# CITY OF ALBUQUERQUE

December 16, 2019

RE: **Lot 4 Block 6 Unit 18, S.A.D. 228**  
**Volcano Cliffs Subdivision**  
**6616 Kimmick Rd. NW**  
**Grading and Drainage Plan**  
**Engineers Stamp Date; 7-27-19 (D10D003M4)**  
**Pad Certification Date; Not provided**

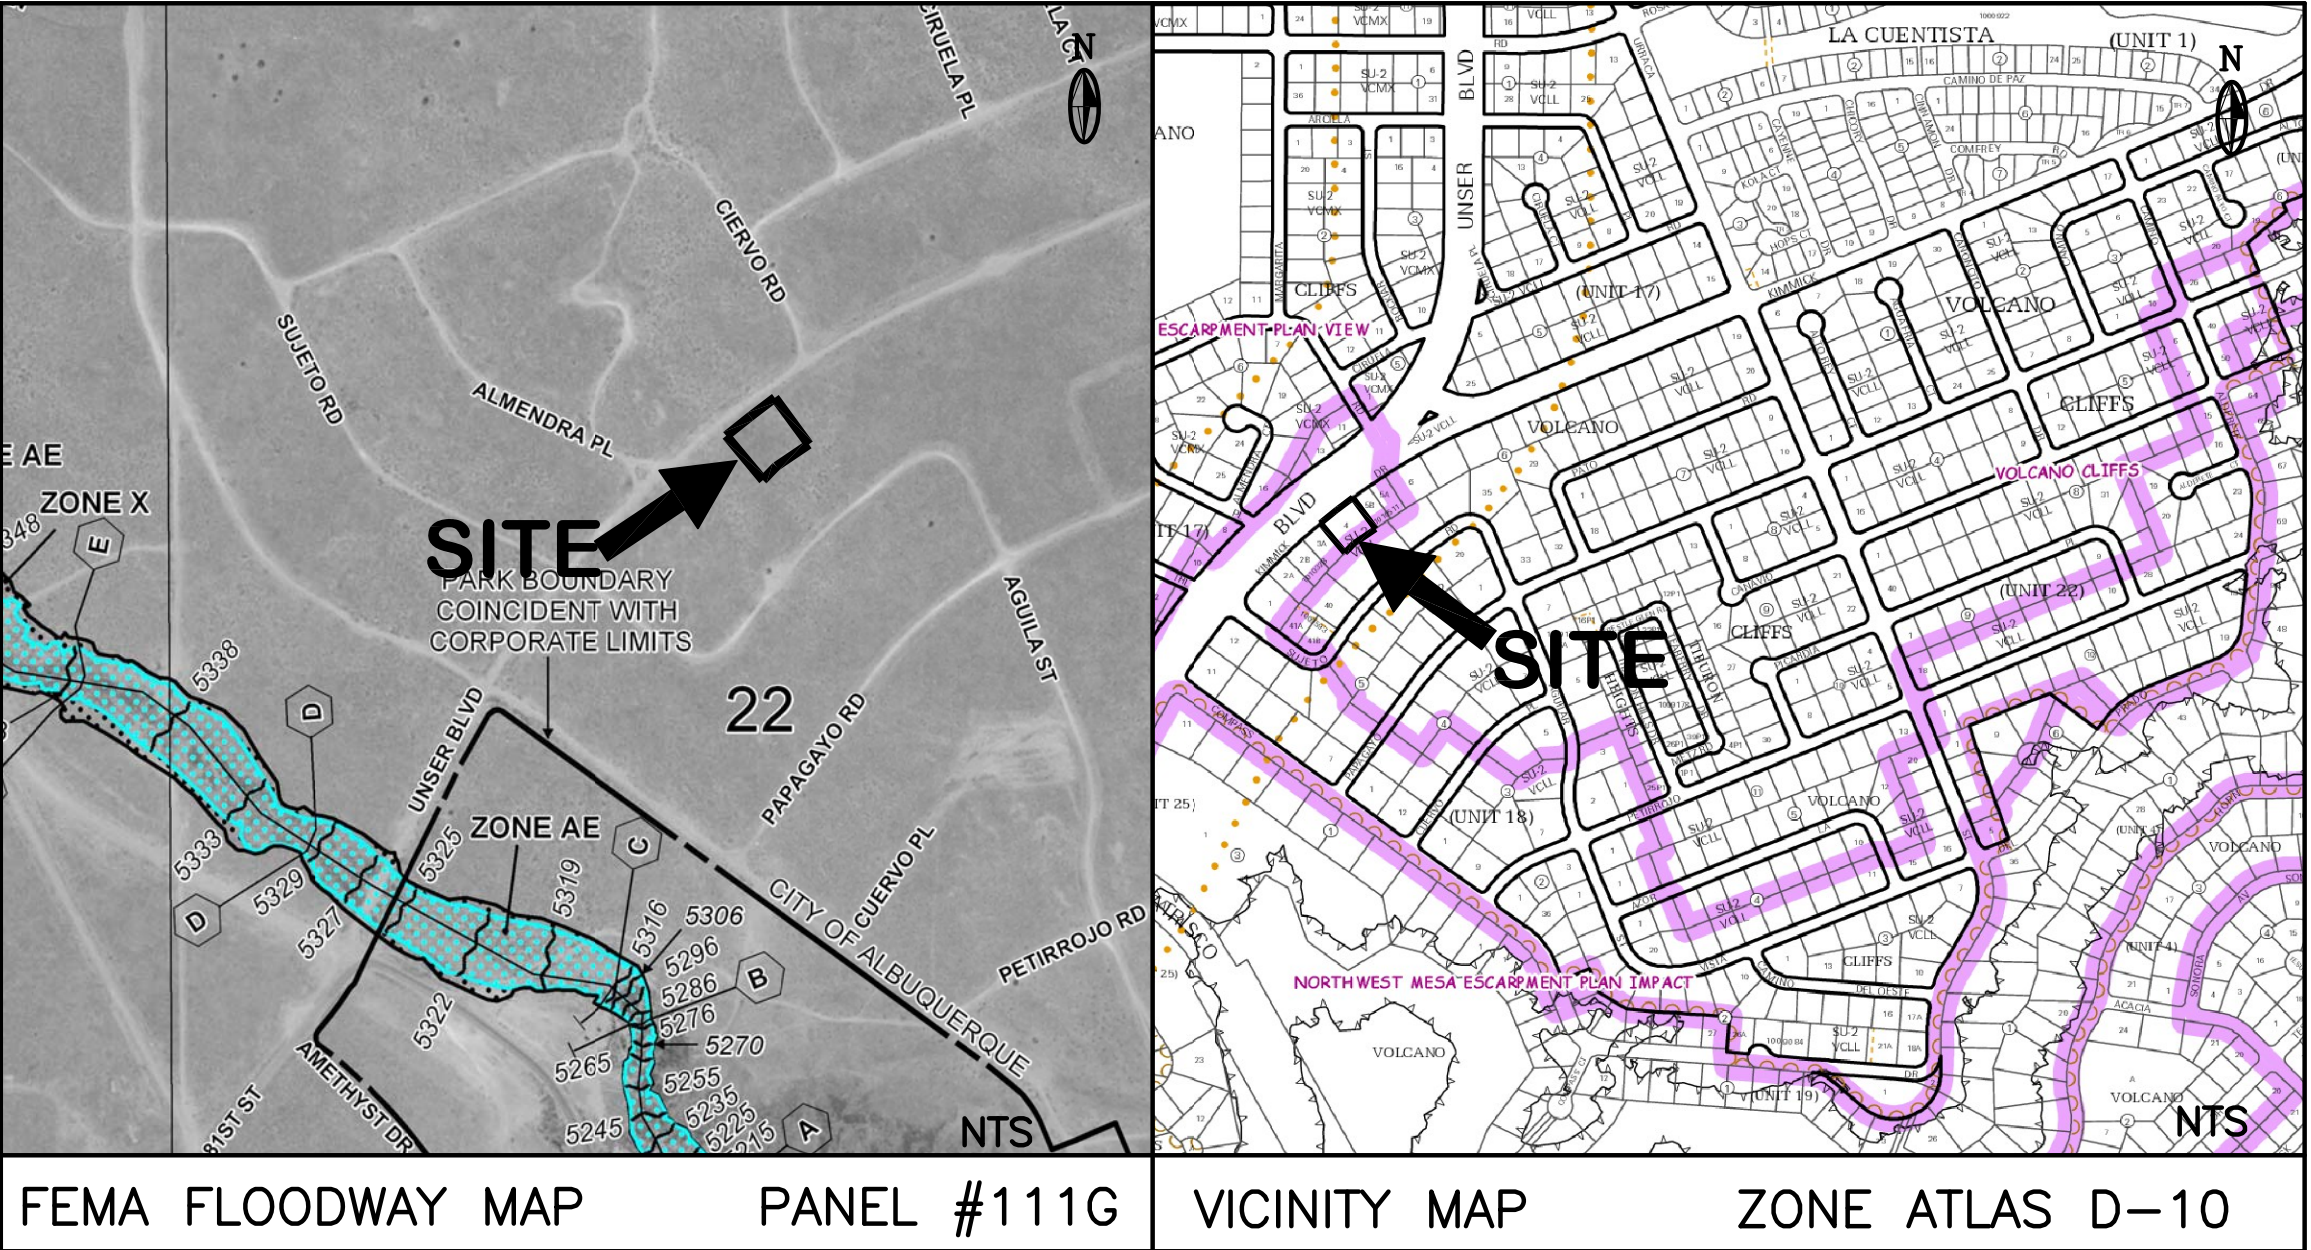
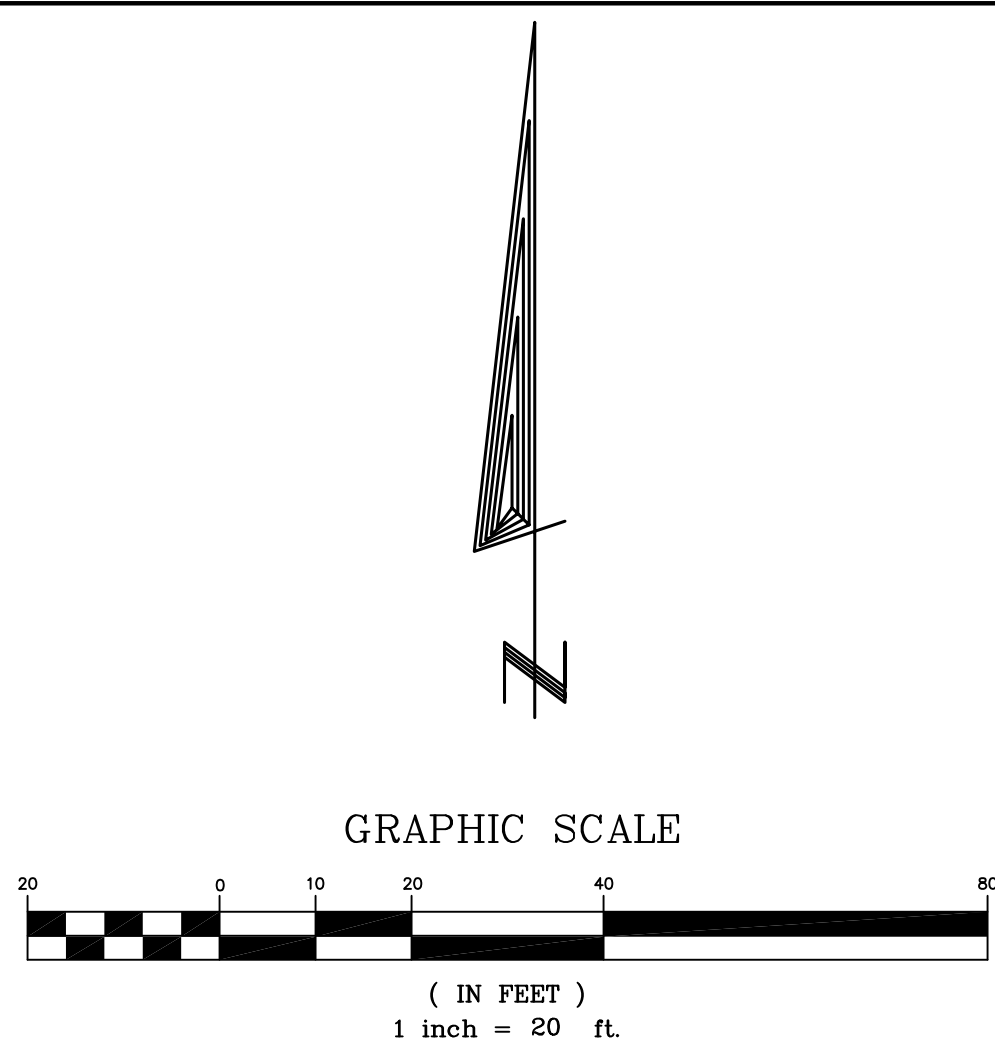
Based upon the information provided in your submittal received 12/13/19, this plan cannot be approved for pad certification until the following comments are addressed.

- Provide the Pad Certification language, sign and date.
- Building pad not present. Make a site visit before asking for pad certification.
- Have all dirt and debris removed from the public right of way. Make sure they sweep the street and sidewalk.
- Provide the percent amount of land treatment C.
- Provide an accurate amount of land treatment D. Include the amount around the pool area. This may increase the amount of precipitation to be held on site.
